Our ref: Deep Creek Quarry (SSD-11591659)

Subject: Deep Creek Quarry (SSD-11591659) - Request for Additional Information

Fig 1. Noise Sources for Stage 1, Scenario 2.

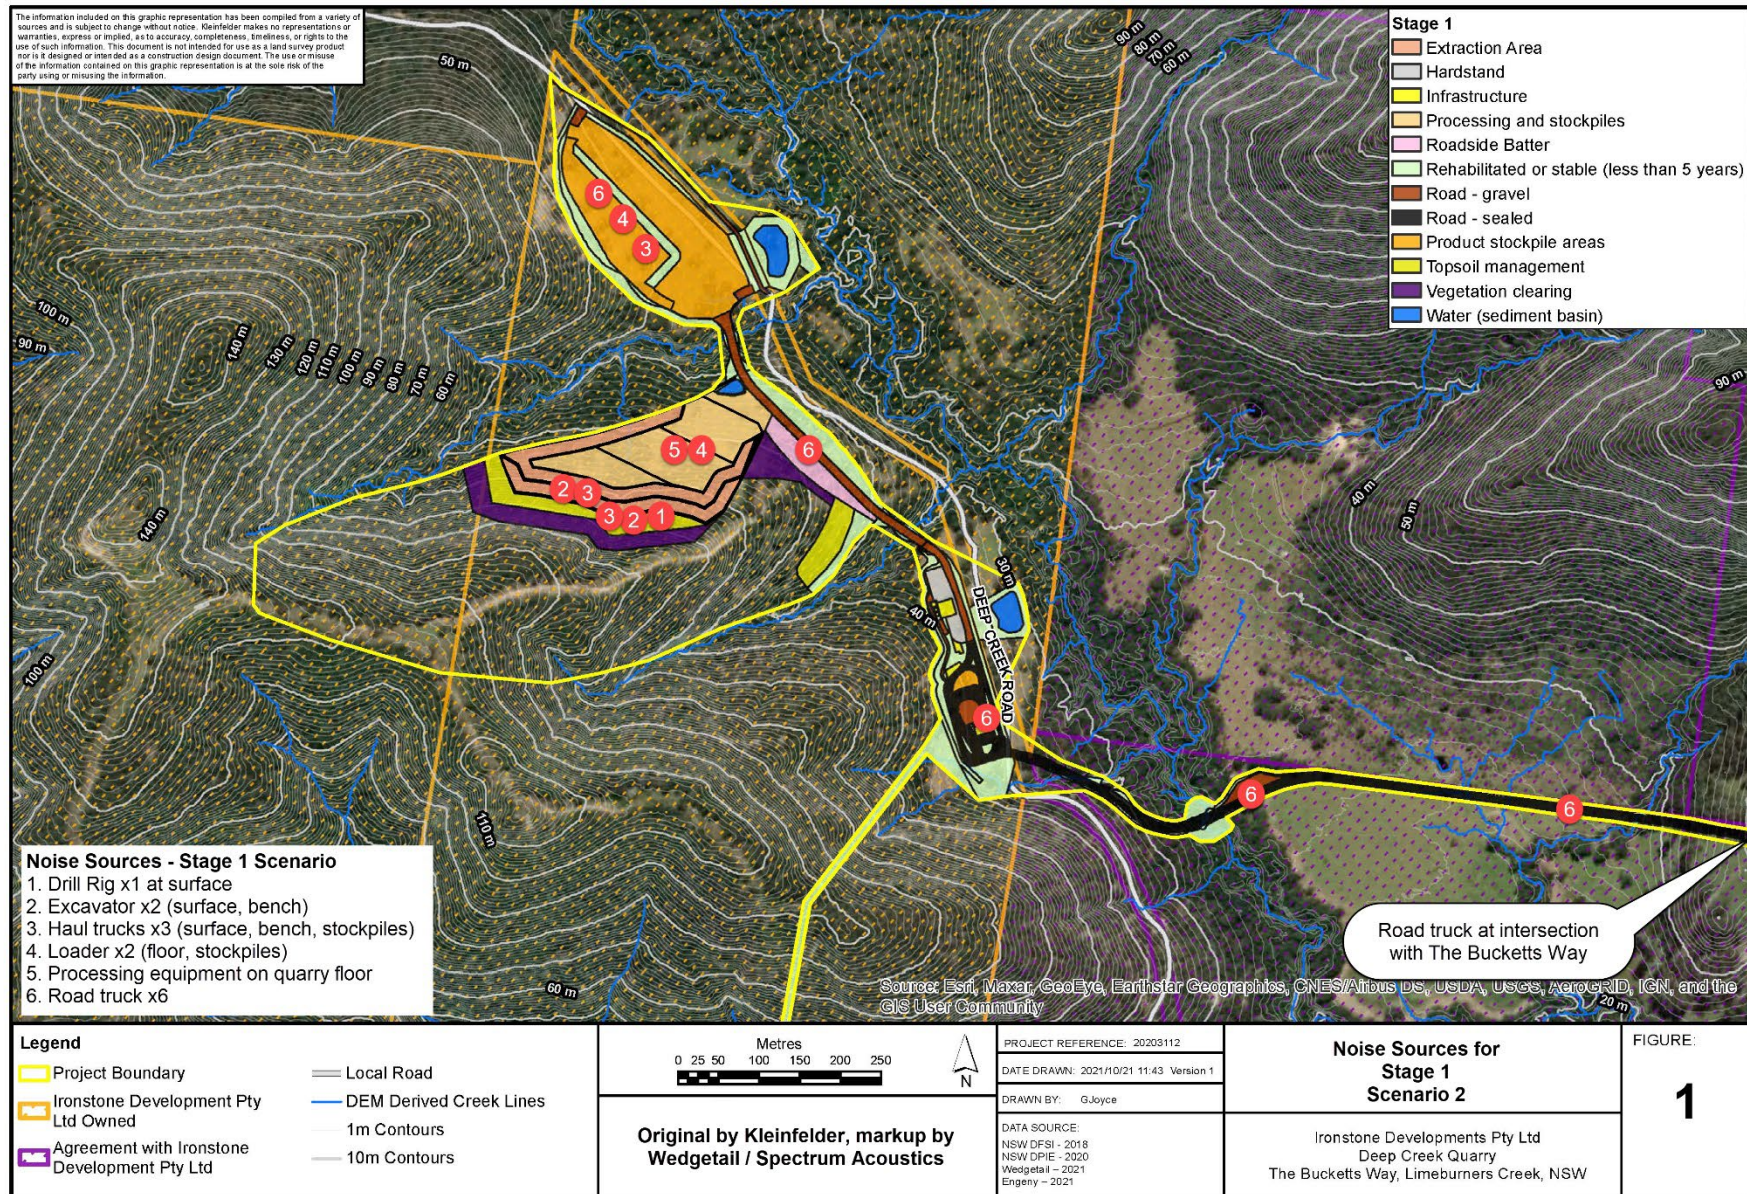
I refer to the Noise Impact Assessment for the Deep Creek Quarry (SSD-11591659). After careful consideration, the department is requesting that you provide additional information to demonstrate that the assessment is representative of a reasonable worst-case scenario, including:

- that the plant and equipment locations adopted for the various operational modelling scenarios are representative of the likely most exposed and/or closest locations to sensitive receptors;
- that all key noise generating activities have been included in the assessment, including proposed stockpiling and overburden emplacement;
- that the appropriate sound power level (SPL) has been adopted for each activity included within the construction and operational noise assessments;
- that the proposed maximum production rate has been modelled in the assessment;
- that an assessment of night-time operational impacts for product loading and dispatch activities proposed between 6 am and 7 am Monday to Saturday has been undertaken; and
- that potential night-time impacts have been assessed against appropriate night-time Project Noise Trigger Levels (PNTLs) for all sensitive receivers.
